8th January 2015

**Planning Application - LU/328/14/PL
Unit 10 Martello Enterprise Centre, Courtwick Lane,
Littlehampton West Sussex BN17 7PA**

Proposed Extension for RJH Construction
Unit 10 Martello Business Centre, Courtwick Lane, Littlehampton
- AS EXISTING + Proposed Roof Plan

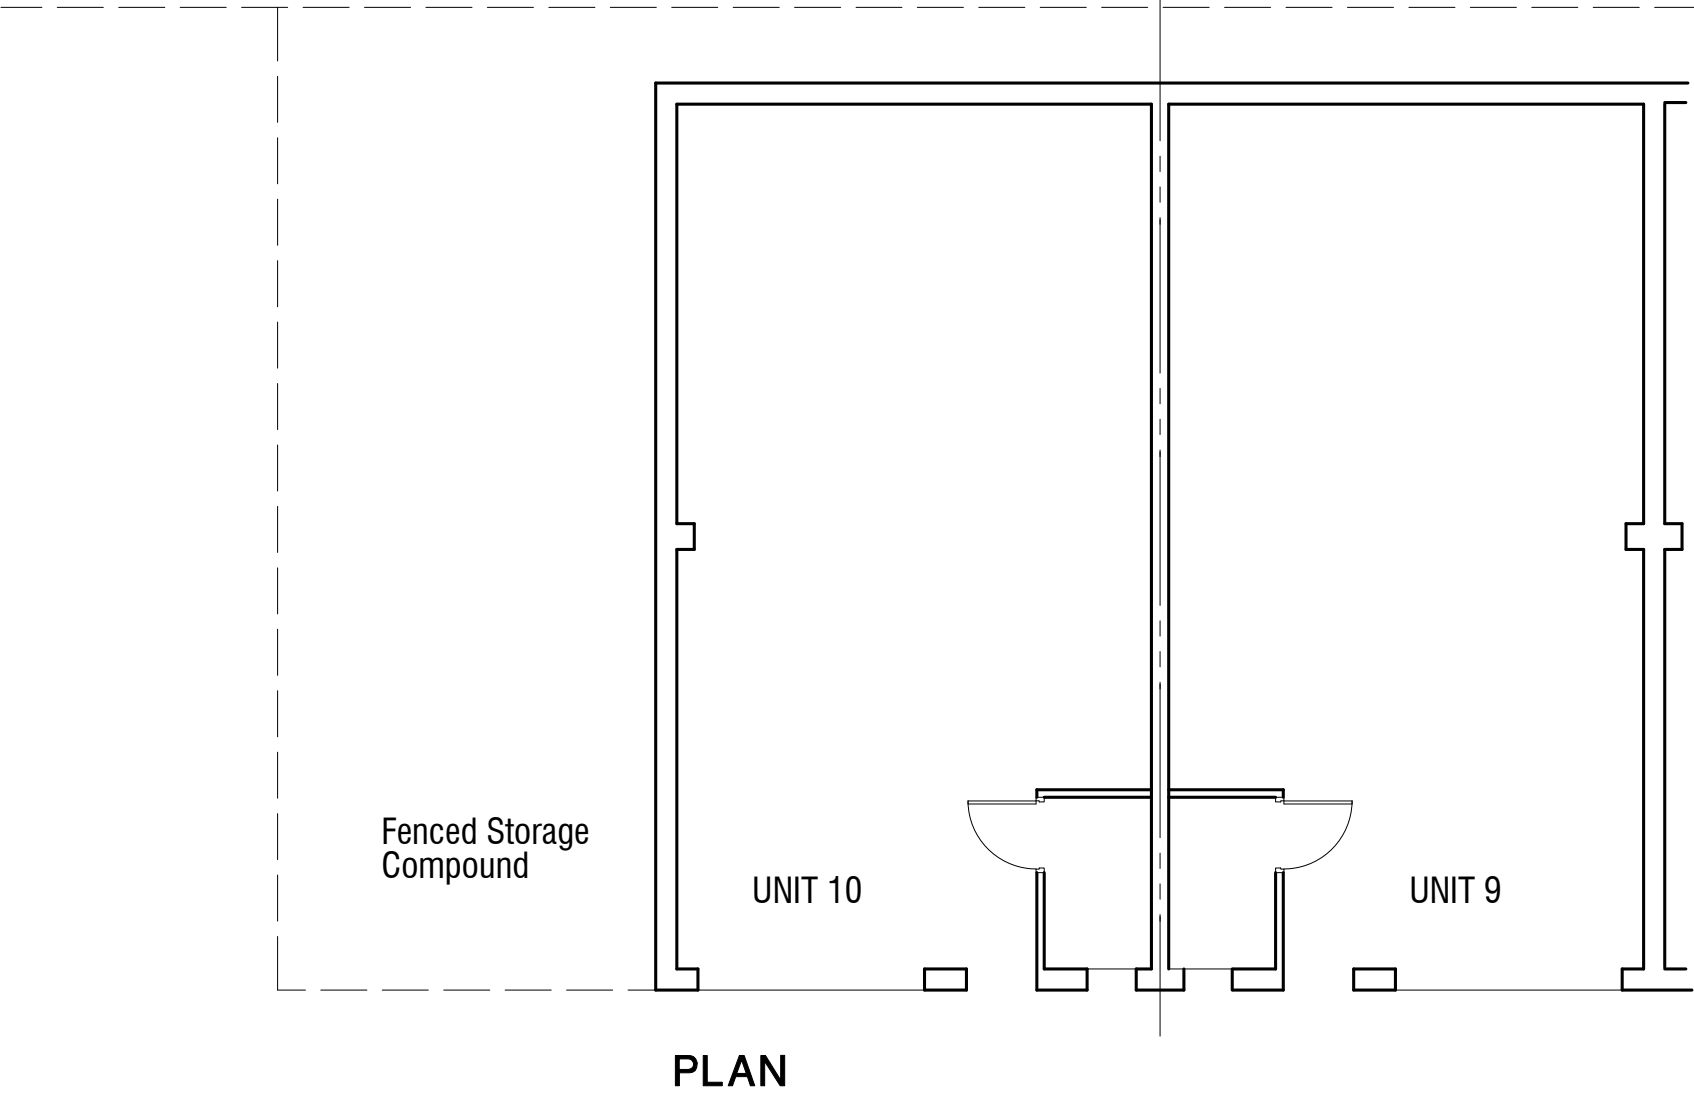
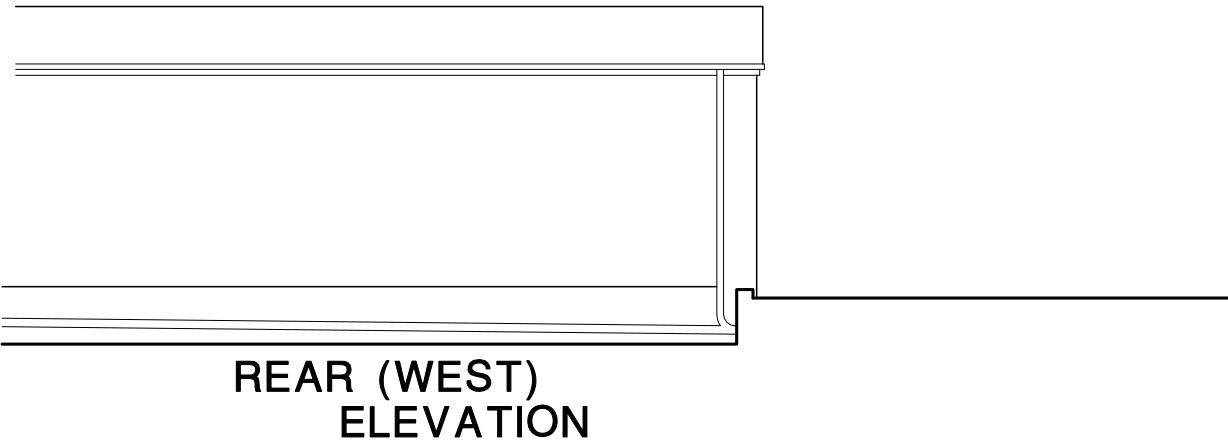
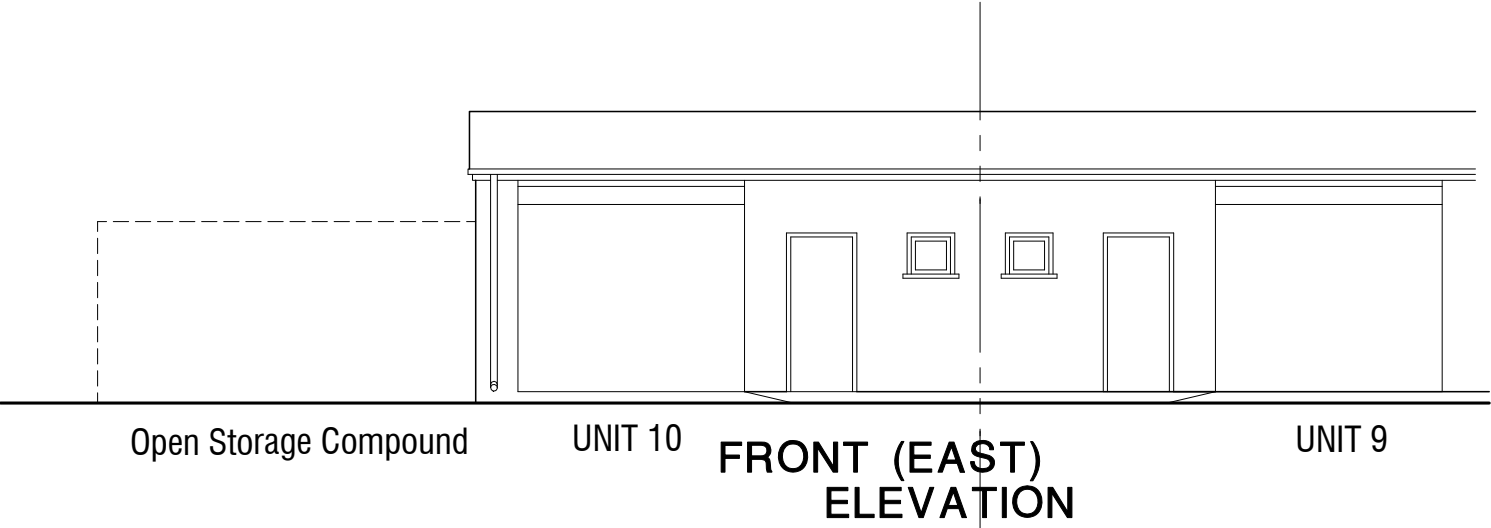
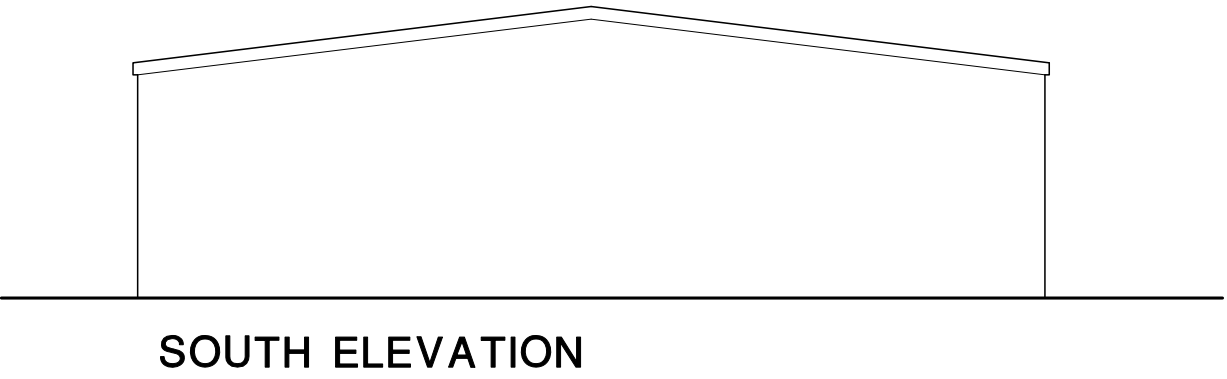
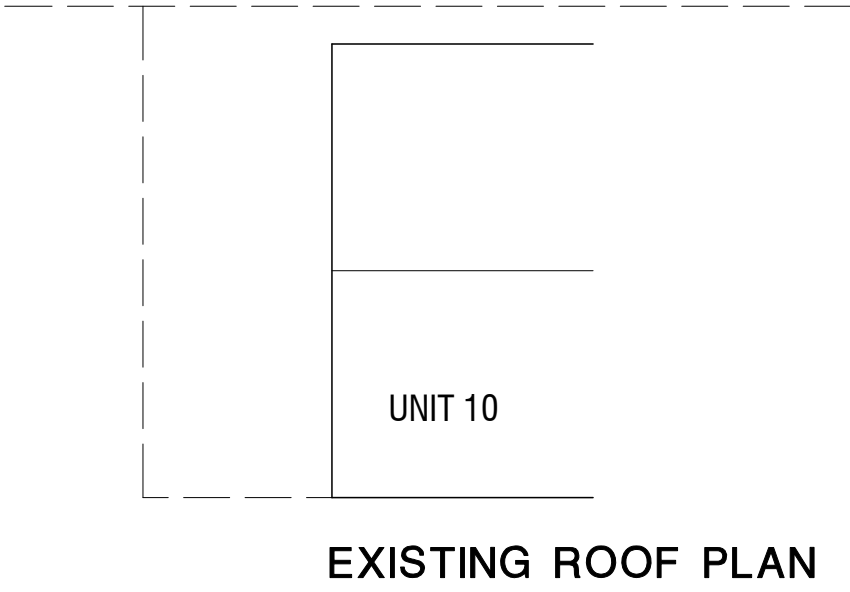
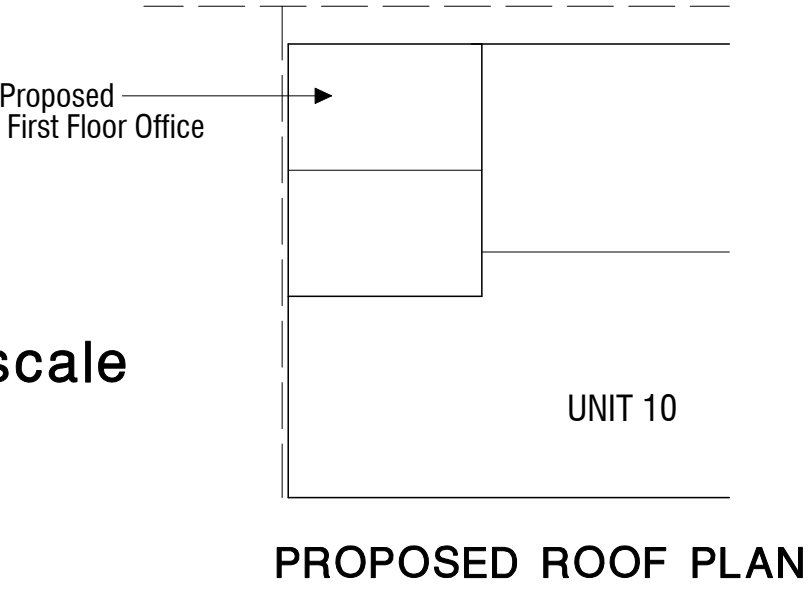
Furthermore, and more importantly, this trading estate has a recent history of damage being caused to parked vehicles on the estate as a result of large Lorries attempting to manoeuvre around the sharp corner directly adjacent to Unit 10. The Managing Agents have in the past attempted to solve these issues by the placing of a metal post alongside the estate roadway to protect such vehicles - which has limited effect. We are currently fortunate that one of the larger tenants (Unit 11-13) have temporarily sacrificed some of their parking spaces to assist visiting vehicles in taking a wider turning radius to help alleviate the problem, but this goodwill is only temporary and could be rescinded at any time without recourse should these car parking spaces be needed by them in future.

Any expansion of business activities within unit 10, or indeed the addition of a new separate unit adjacent to unit 10, can only exacerbate future problems by making it even more difficult for such large Lorries to turn this corner safely and without damage to property.
